## PC Comment Response Letter

**Subject:** PC Comment Response Letter  
**Address:** 4029 97<sup>th</sup> Ave SE  
**To:** City of Mercer Island

**Review Type:** Intake  
**Reviewer Name:** Ruji Ding

C-2.00

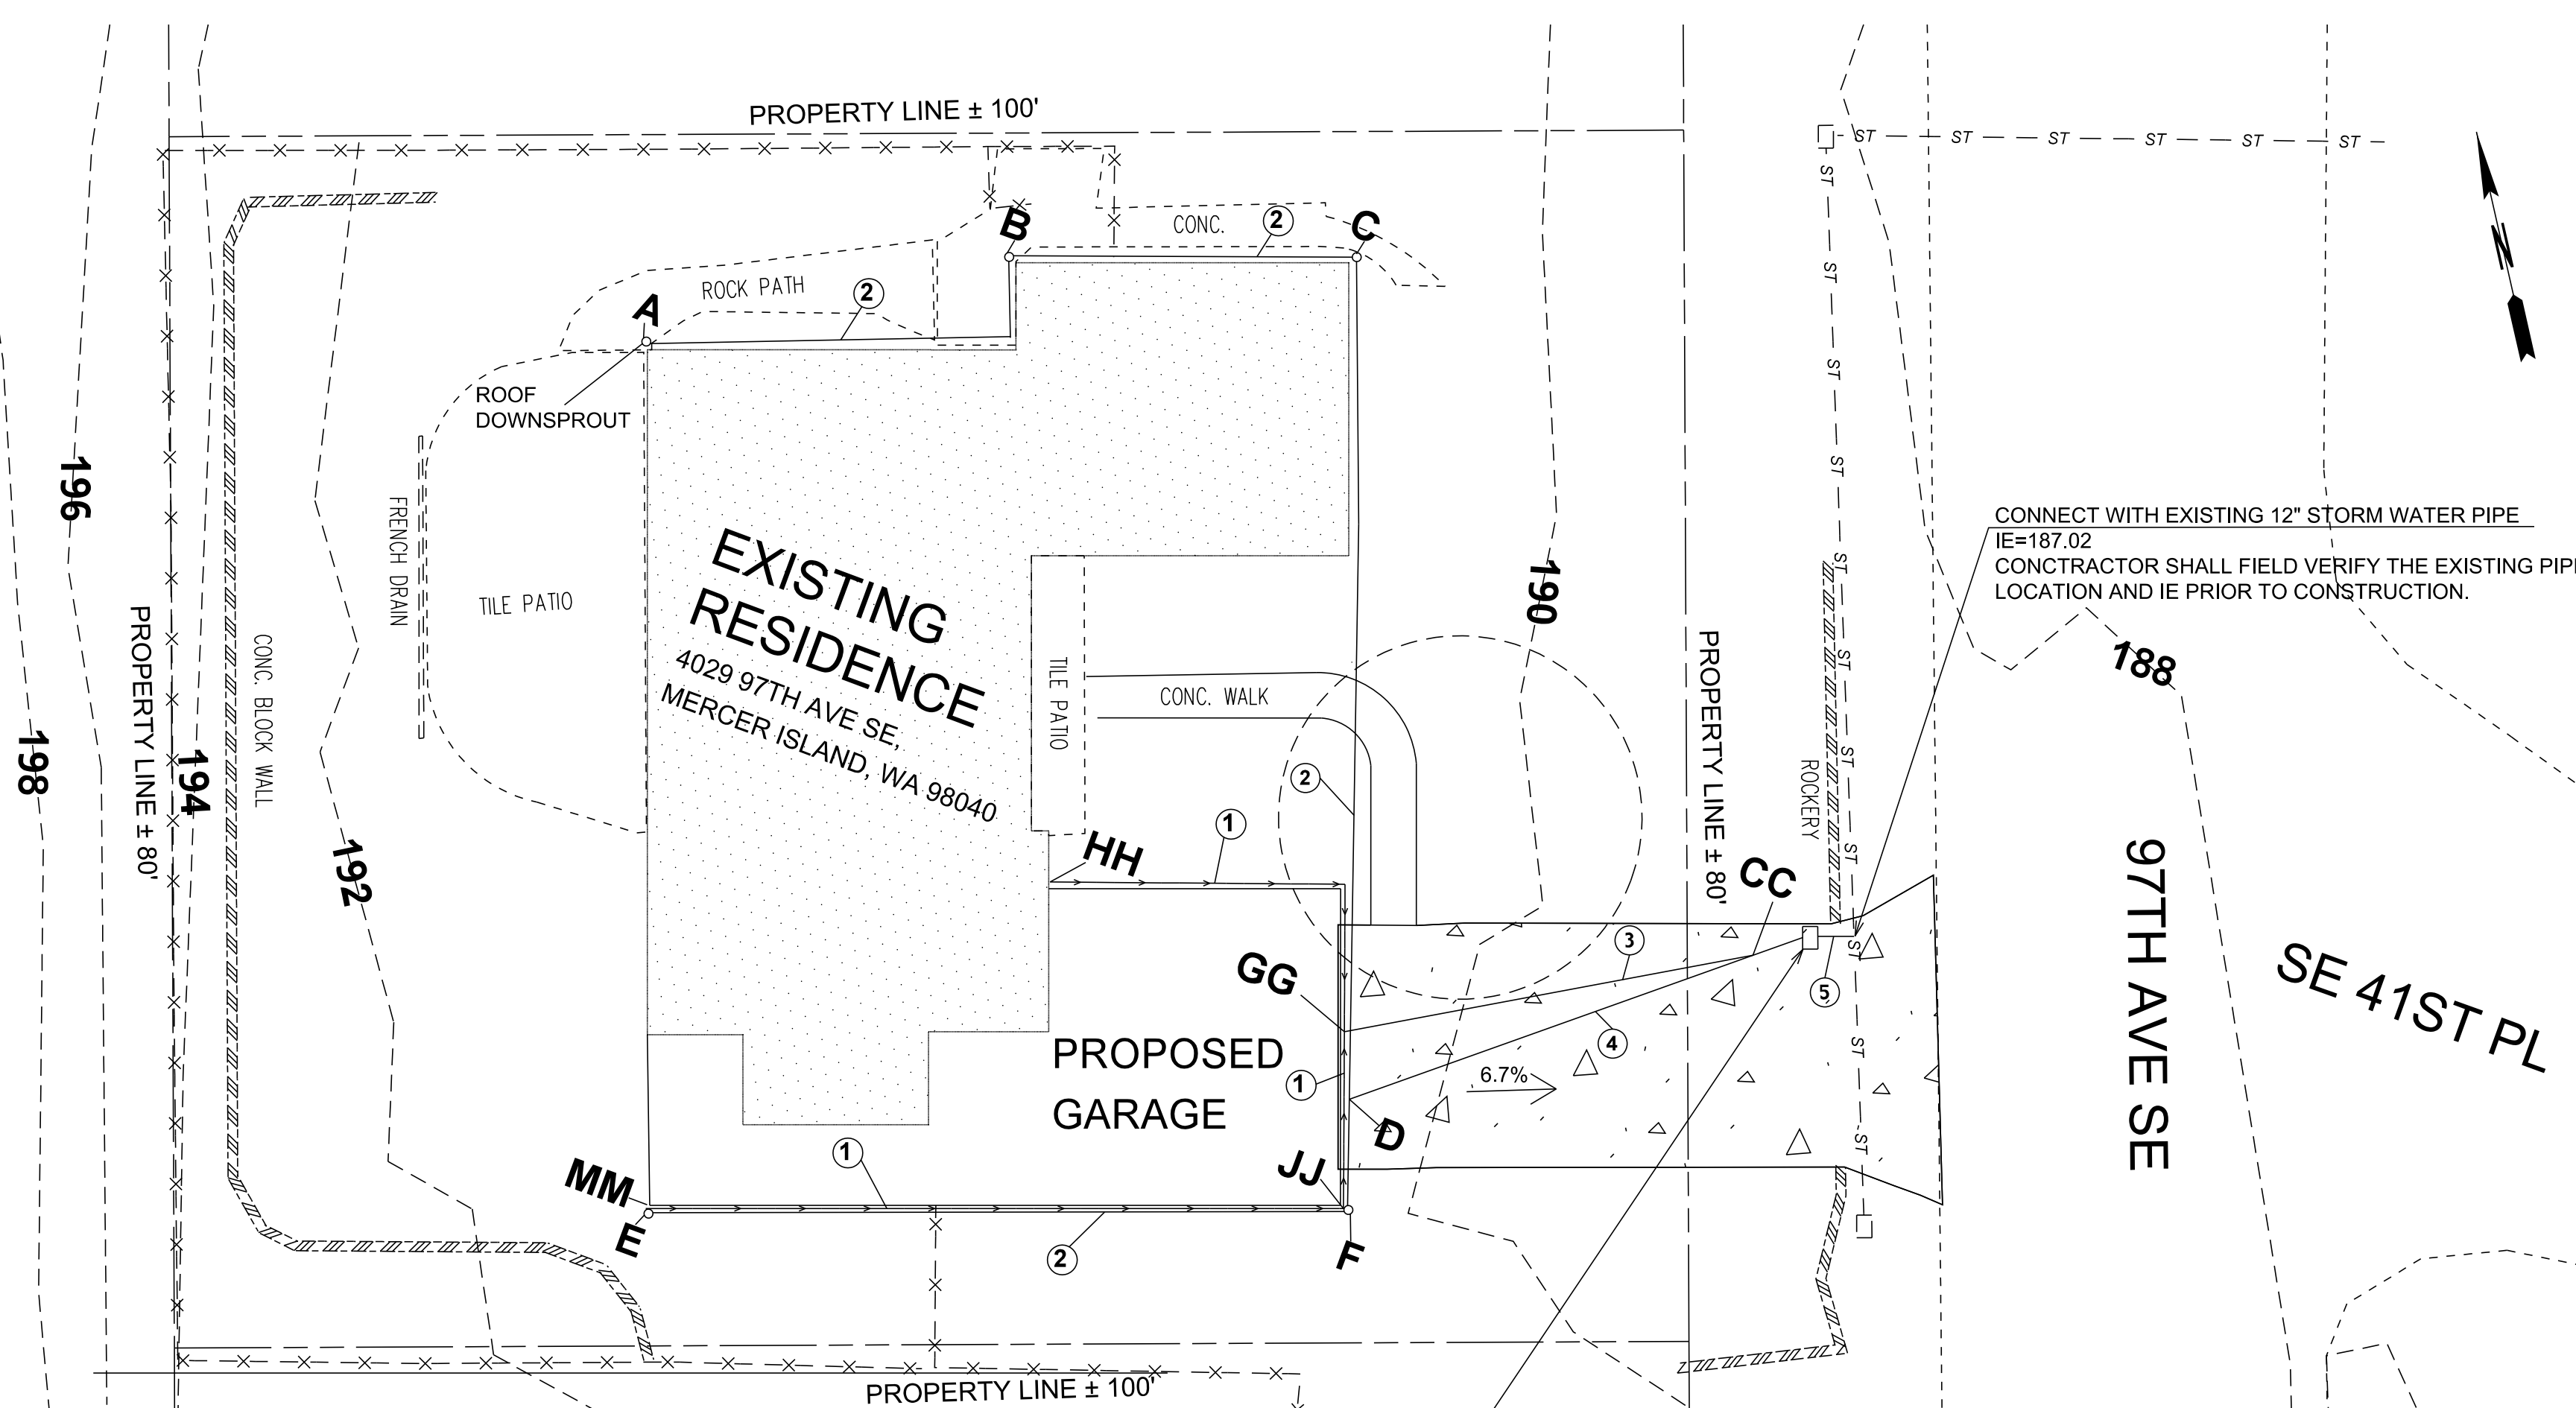
1. The drainage report shows that this project will result in more than 2,000sf of new plus replaced hard surface area. Per MICC 15.09.050, this project will an onsite detention system. The current drainage plan and report do not show an onsite detention system.

*Response: The accurate total of new/replaced impervious is 1393 sq-ft. The drainage report has been updated to reflect this. The civil plans on sheets C-1.00, C-2.00, C-3.00 and C-4.00 have also been updated accordingly.*
